APPENDIX J - Epic Mining Luddenham Quarry Water Management Plan Prepared by VGT

APPENDIX K – Correspondences from Government Agencies (DoPI, OEH, EPA, etc ...)

**Luddenham Clay Shale Quarry (DA 315-7-2003)
Stockpile Modification**

Approved : _____ SHEET No. 6 OF 6 SHEETS
 Computer Ref : 01019-T6
 Proj. Name : _____
 REF : **01019-T6**

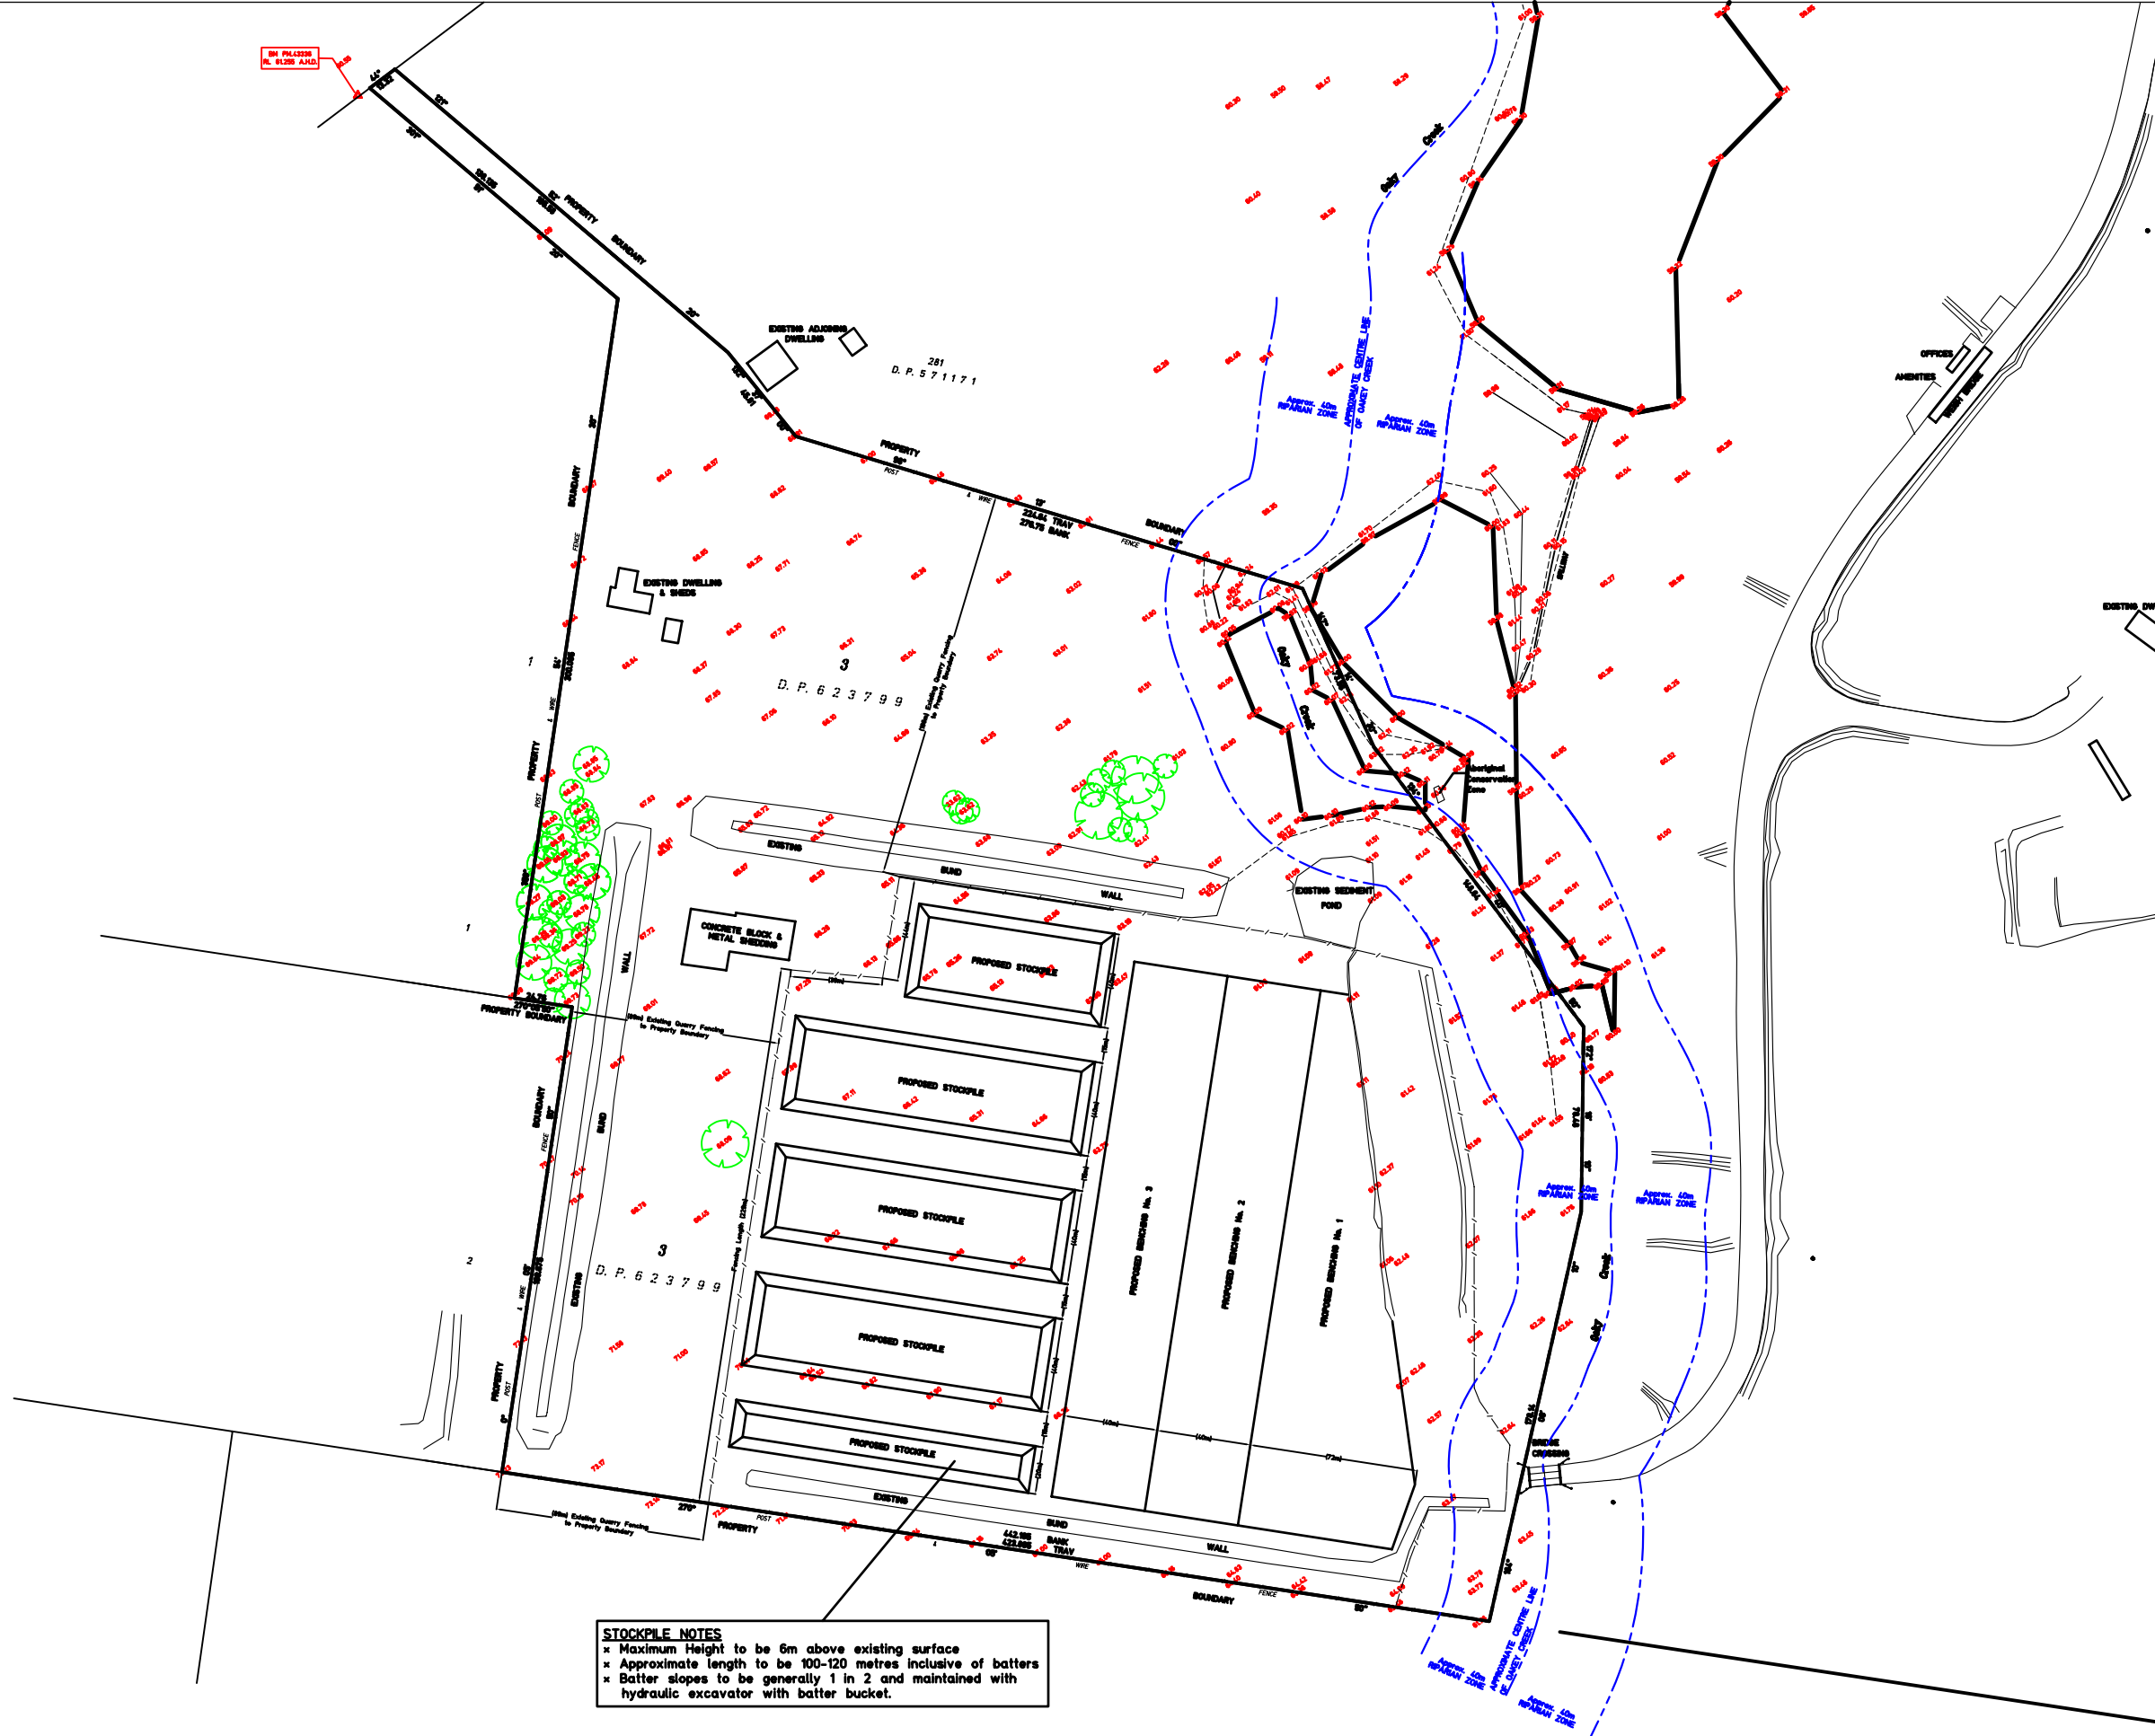
Information provided to date about the proposed stockpiles (gleaned from figure 01019-T6) includes a maximum height of 6m, an approximate length of 100-120 m and a batter slope of generally 1 in 2. Additional information to be provided includes the maximum proposed volume of material to be stockpiled, the maximum predicted area covered by the stockpiles, and how storage and handling of the material in the stockpile would occur (for example, equipment types and numbers to be used in managing the stockpiles, for how long the stockpiles are to be utilised, how long each stockpile would remain on site and how material in the stockpiles would be cycled over time).

It is also noted that the plans provided do not appear to reflect the configuration of stockpiles that have been constructed to date (as shown in the aerial photograph dated 16 May 2011). If the modification is approved, stockpiles would need to match the configuration shown in the figures provided in support of the modification.
